Project: 115201-5.3.1.5

**RE: RESPONSE TO COMMENTS LETTER  
380 ROLLING MEADOW CRESCENT – SUBMISSION #1**

With reference to the above mentioned submission and your comments in your Memorandum dated December 24, 2018, please see our responses below:

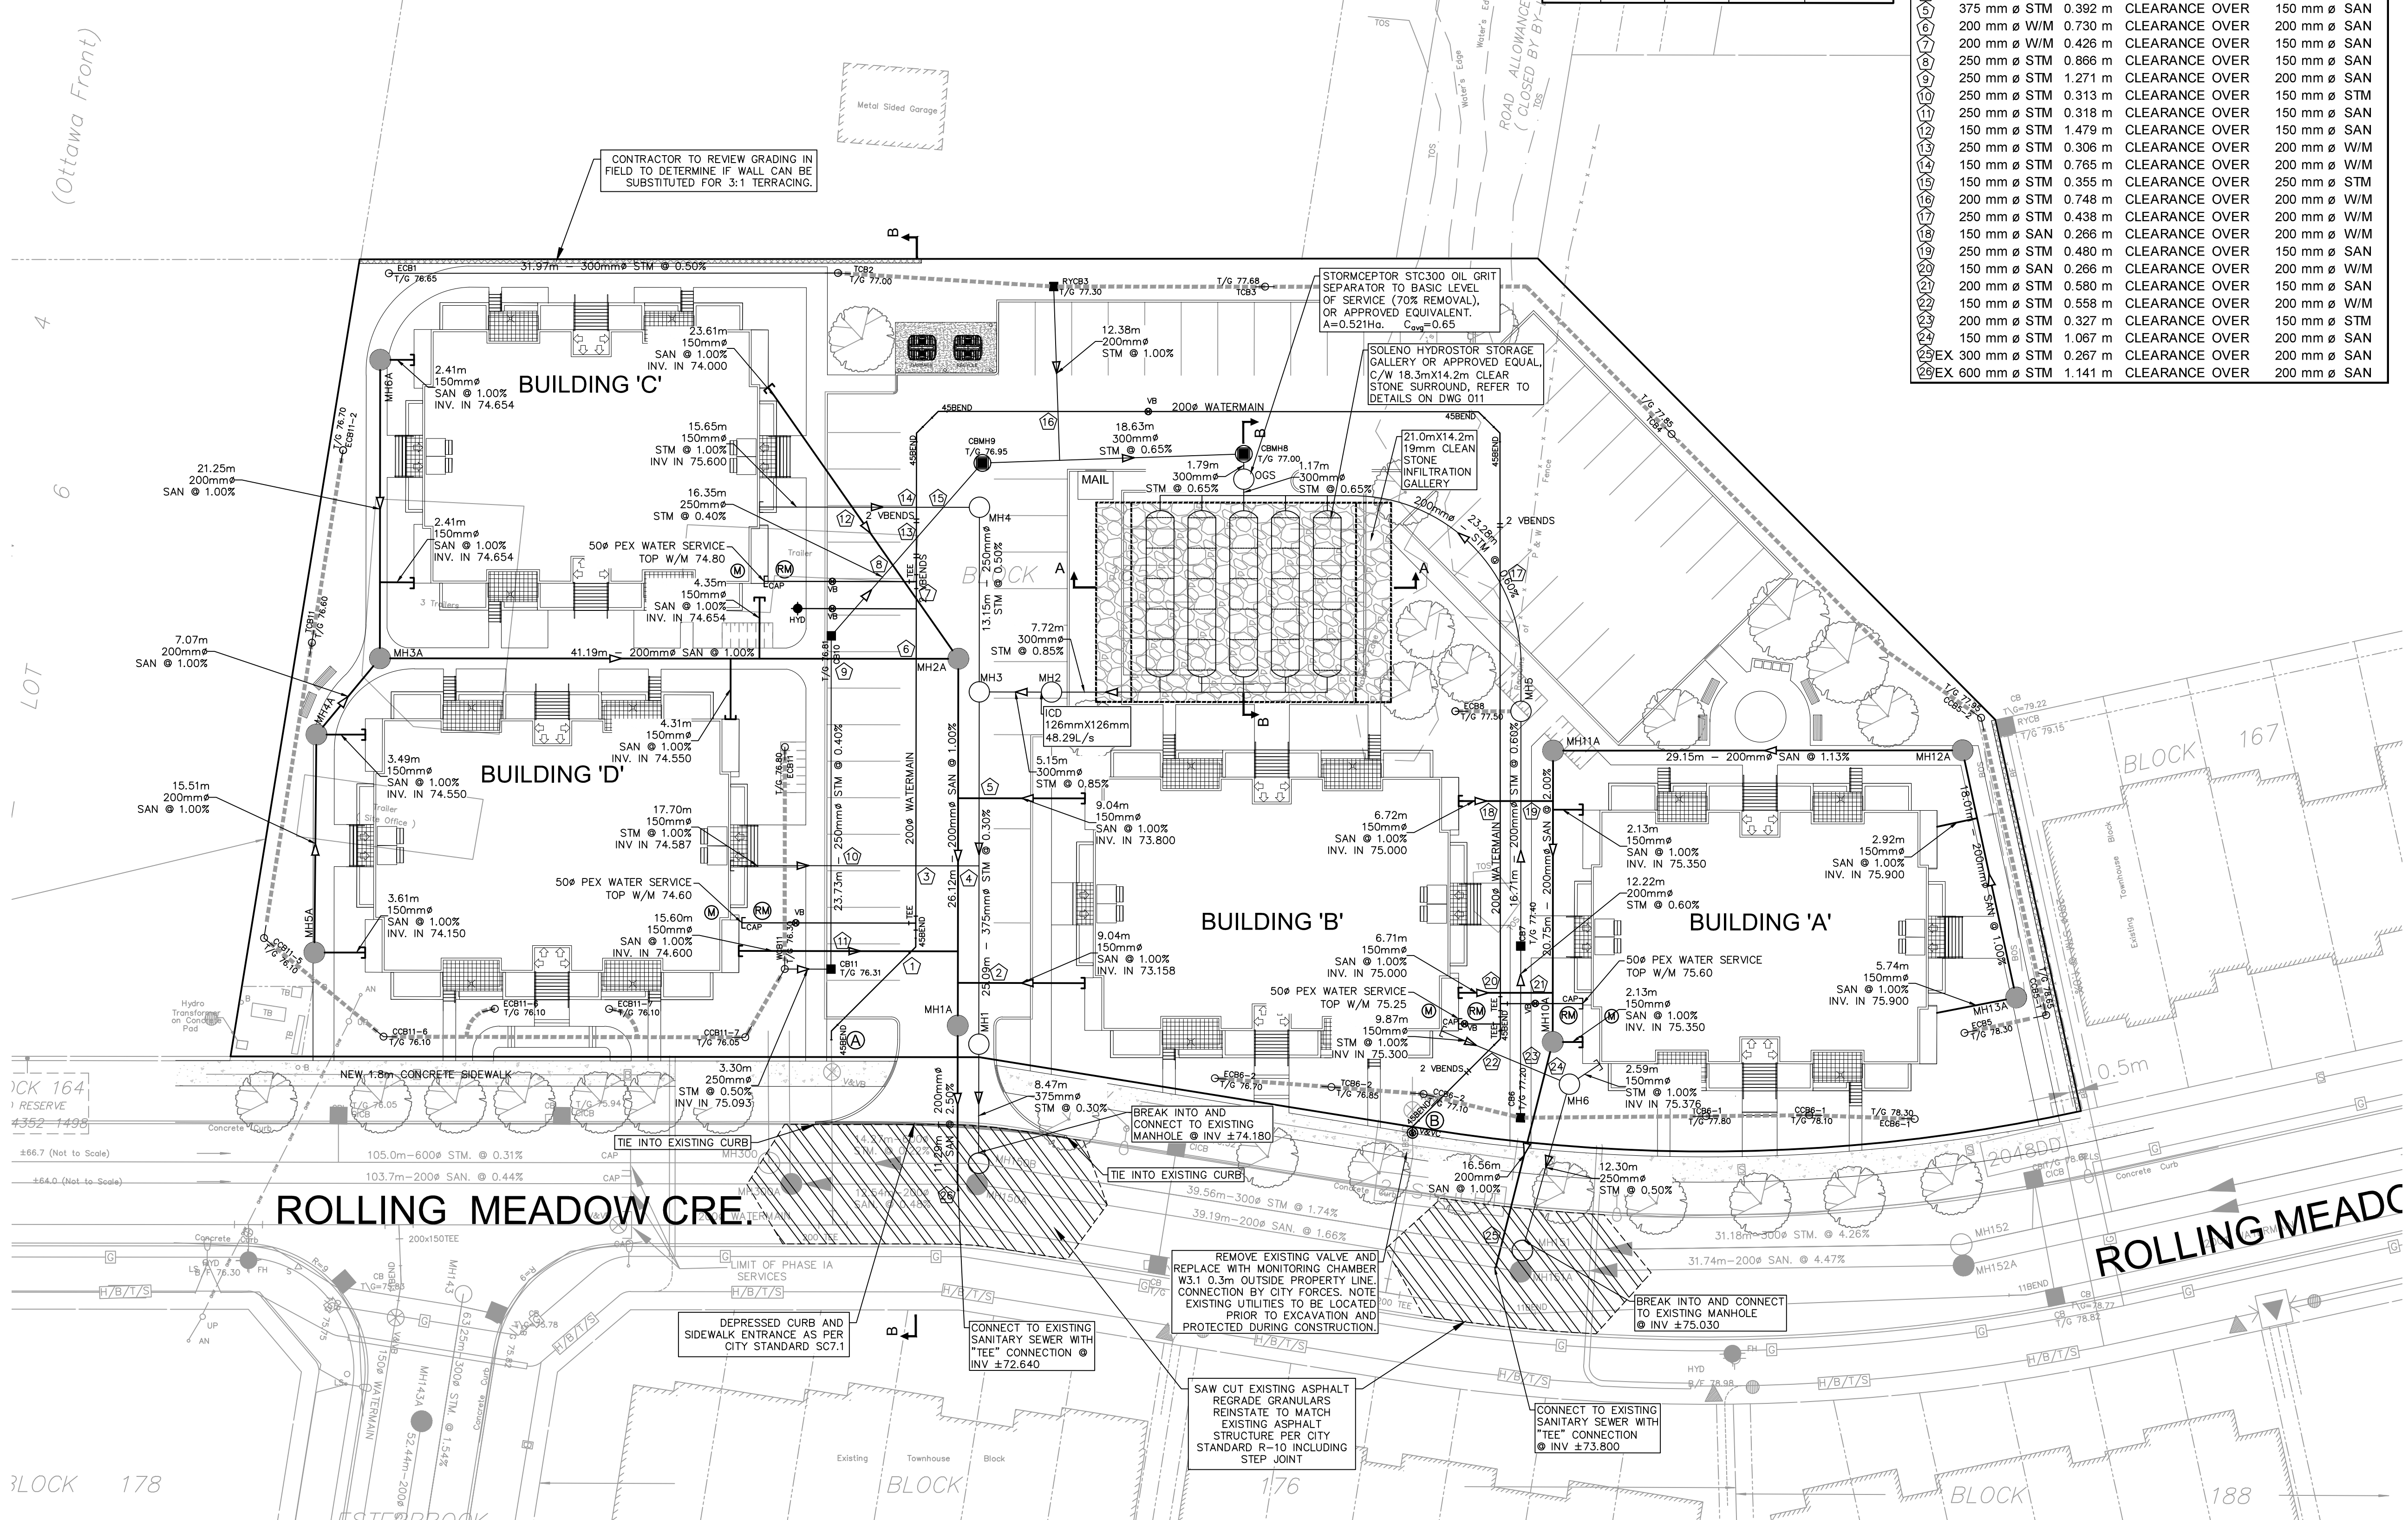
32. Recommend to have a profile drawing accompany this drawing.

33. Specify the water and sewer pipe materials, review the slopes, and ensure that they conform to standards.

34. The water service post in front of Building ‘B’ is to be moved outside the property line.

35. Address backflow prevention for the site.

36. Currently the proposal is to meter at the building level (4 meters) which should be acceptable. The requirement for the 5-year leak survey may still be a requirement due to being borderline on private watermain/service length. If perimeter metering is entertained, the 5-year leak survey will not be a requirement upon registration. Address accordingly.

38. Include a monitoring maintenance hole inside the property line from the private sewer to the public sewer. Refer to the Sewer Use By-Law No. 2003-514 for details.

39. Clarify the elevations of MH3 and the OGS on the STM STRUCTURE TABLE.

40. Verify the lengths and the slopes of the sanitary sewers shown on the servicing drawing against the sanitary sewer design sheet provided in the Servicing Brief, as there is inconsistency in some places (ex: a length of 29.91m and a slope of 2% from MH12A to MH11A on the sanitary sewer design sheet, and a length of 29.15m and a slope of 1.13% on the servicing drawing).

41. As stated for the sanitary sewers, verify the lengths and the slopes of the storm sewers shown on the servicing drawing against the storm sewer design sheet provided in the Servicing Brief.

*Added profile to DWG 011.*

*Note 1 on drawing revised to include water and sewer pipe materials.*

*Revised with note.*

*Refer to mechanical drawings for location and specification of backwater valves. Typically not shown on site servicing drawings, but is a requirement of the Ontario Building Code, and are normally located within close proximity to the building cleanouts.*

*A monitoring valve chamber has been provided at the eastern connection where the existing valve box was located inside private property.*

*Revised. MH1A moved closer to property line. MH1 was already close to property line. MH10A and MH6 have not been moved due to congestion and crossing conflicts to connect to street. MH10A and MH6 are relatively close to property line with no downstream connections, and should be adequate to serve as a monitoring manhole.*

*Revised.*

*Revised.*

*Revised.*
